Subject: WSCC Planning Consultations on: AL/116/18/PL and AL/117/18/PL

DATE 10/16		REV D	
DRAWING EW		SP01	
215818		DRAWING NUMBER	
C/No.		SCALE	
0/No.		1/500 @ A2	
PROPOSED SITE PLAN CHICHESTER LAND AT FONTWELL AVENUE SITE MR DUGGIN FOR SCANDIA-HUS BUSINESS PARK FELCOURT ROAD, FELCOURT, EAST GRINSTEAD, WEST SUSSEX, RH19 2LP : TEL 01342 838060 scandiahus

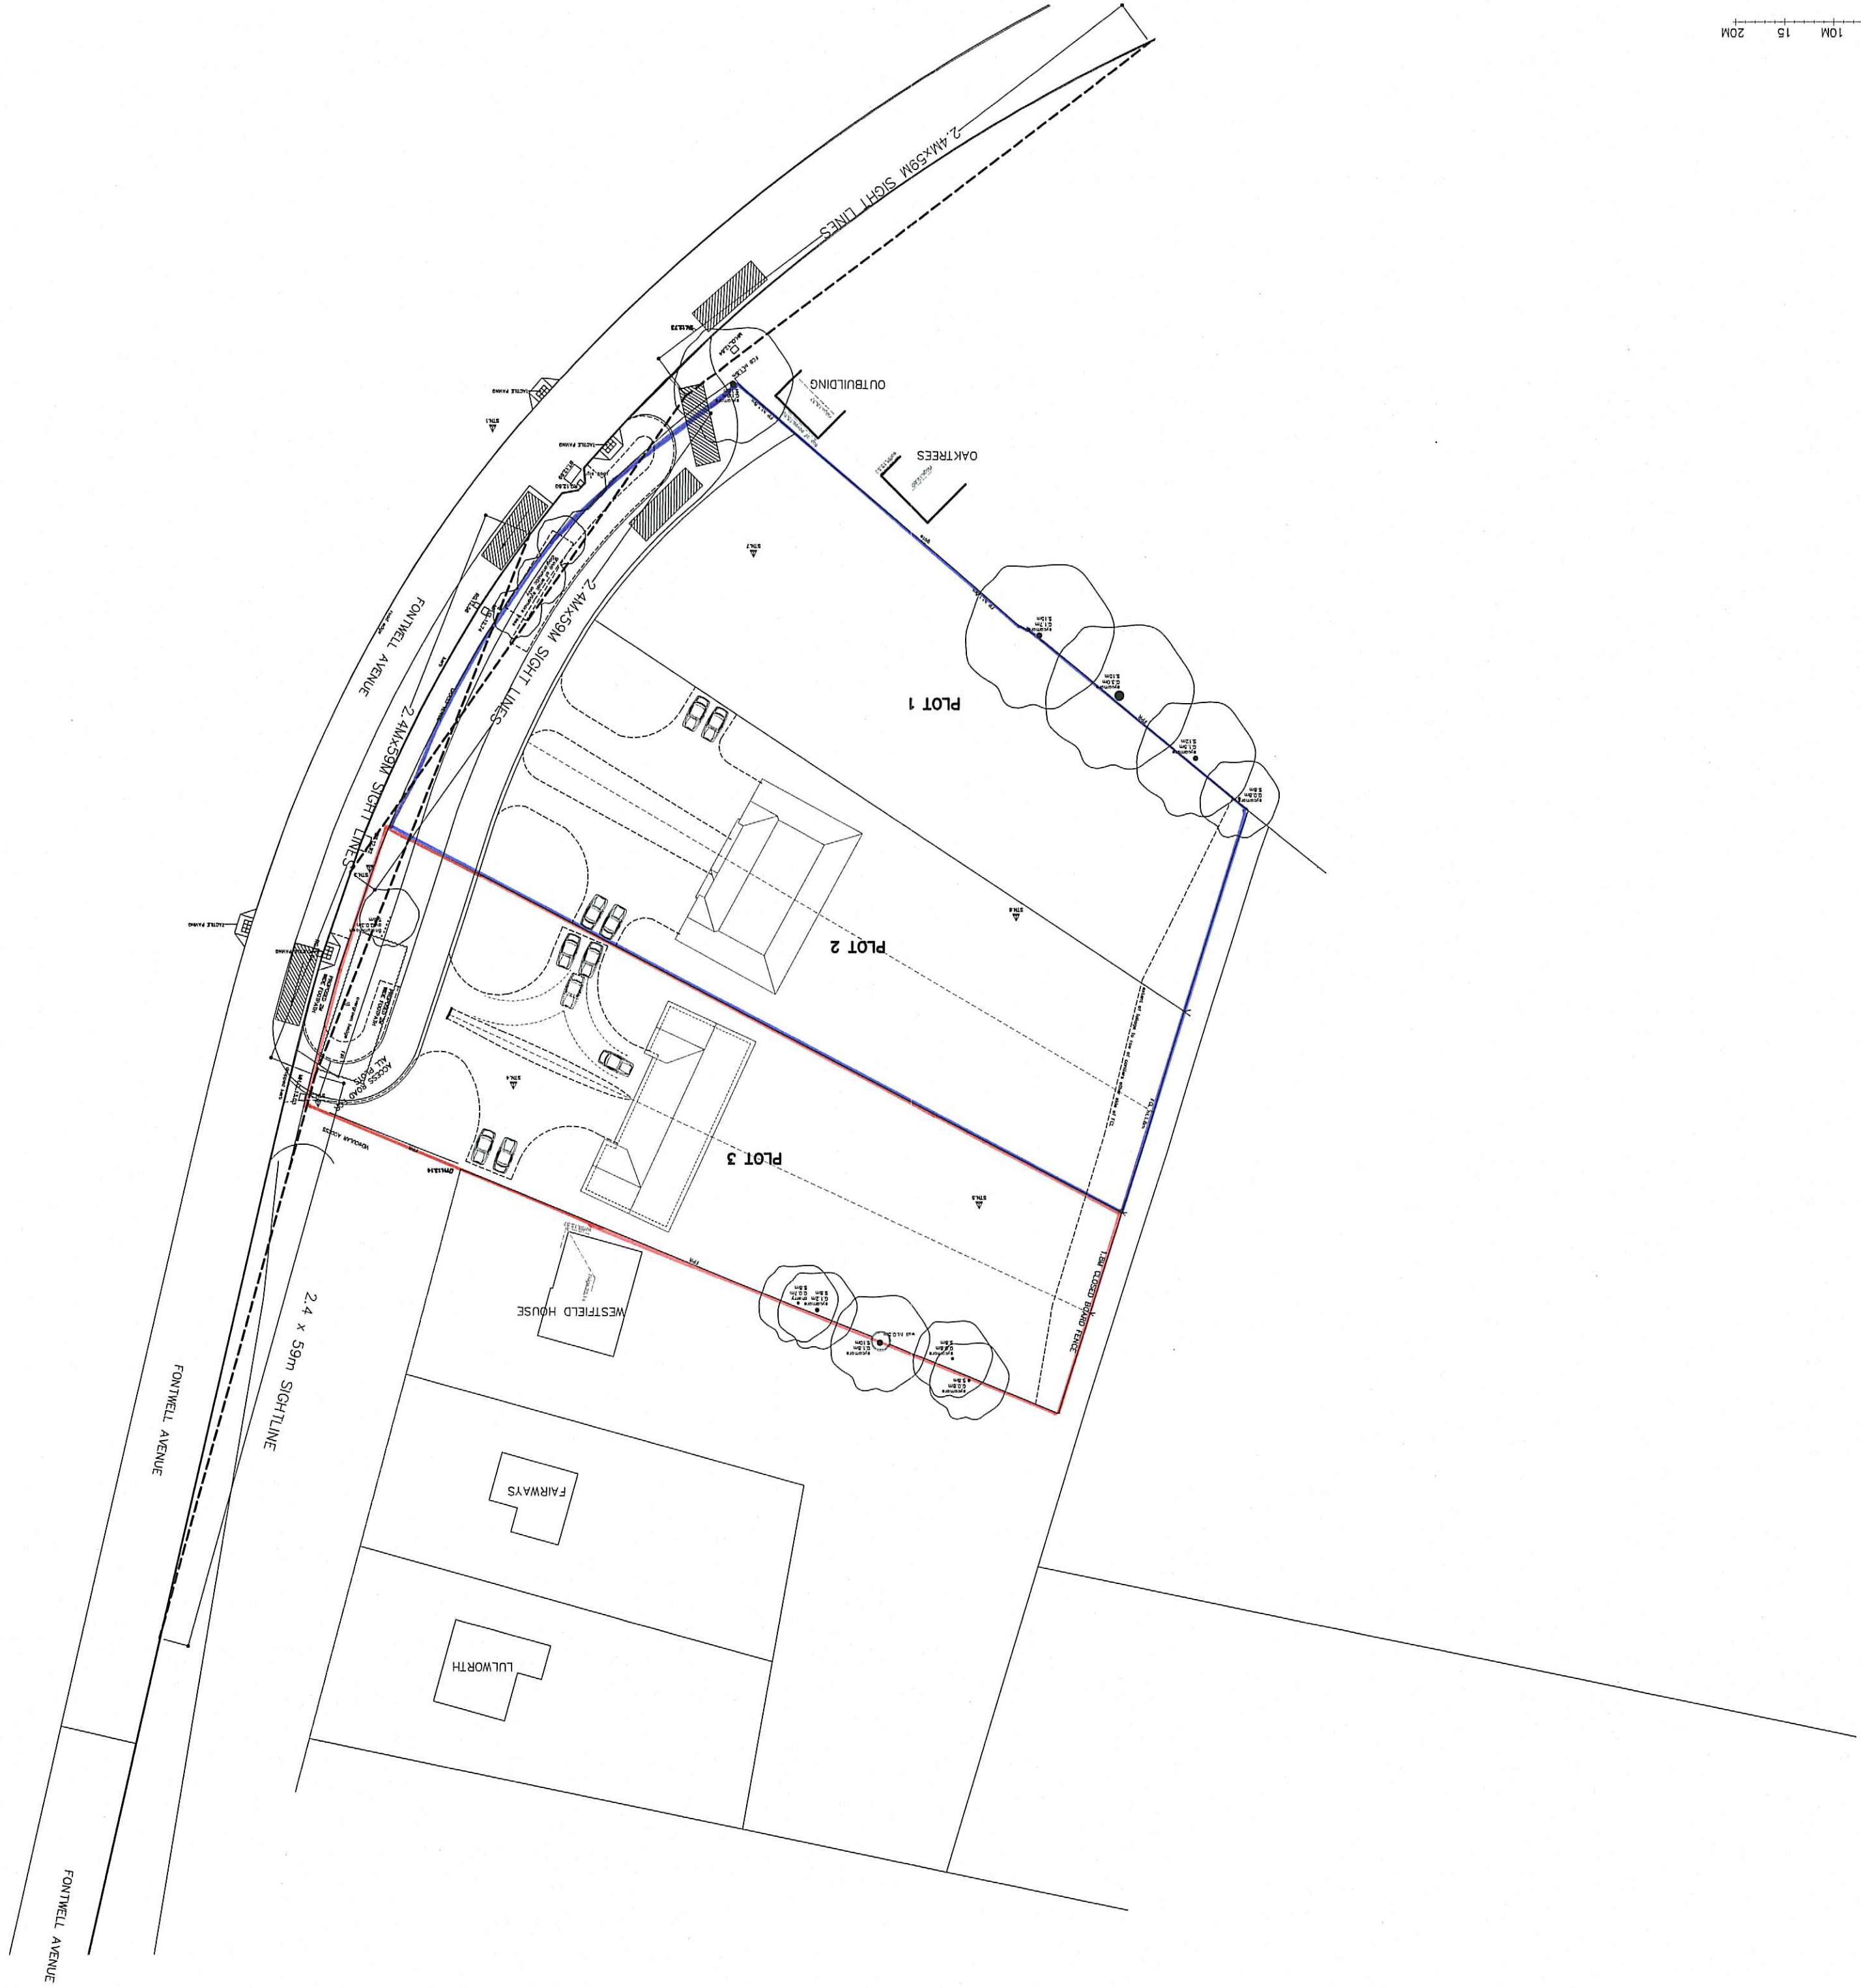
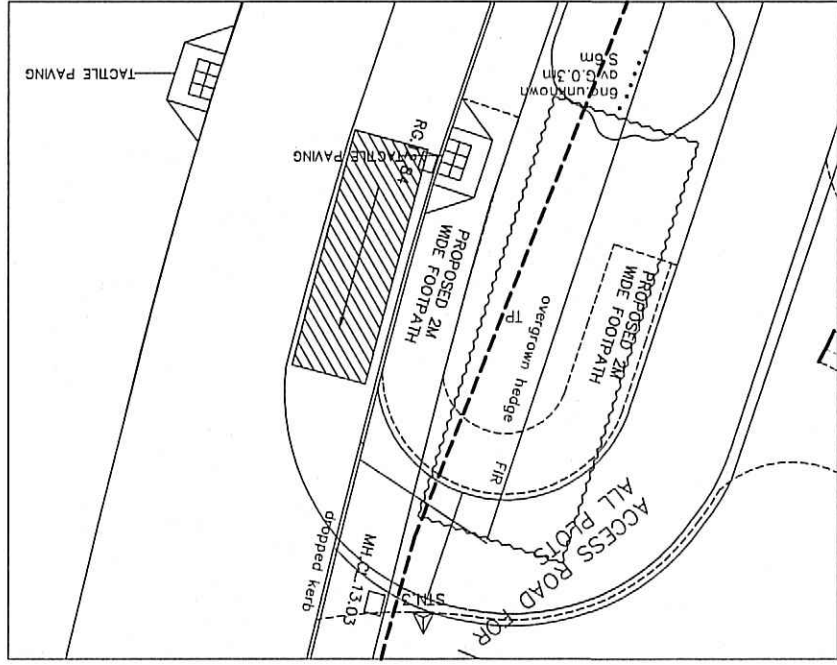
Please see attached responses from Highways. Both raise the same thing. Therefore can you modify both sets of plans as per the request in the responses.
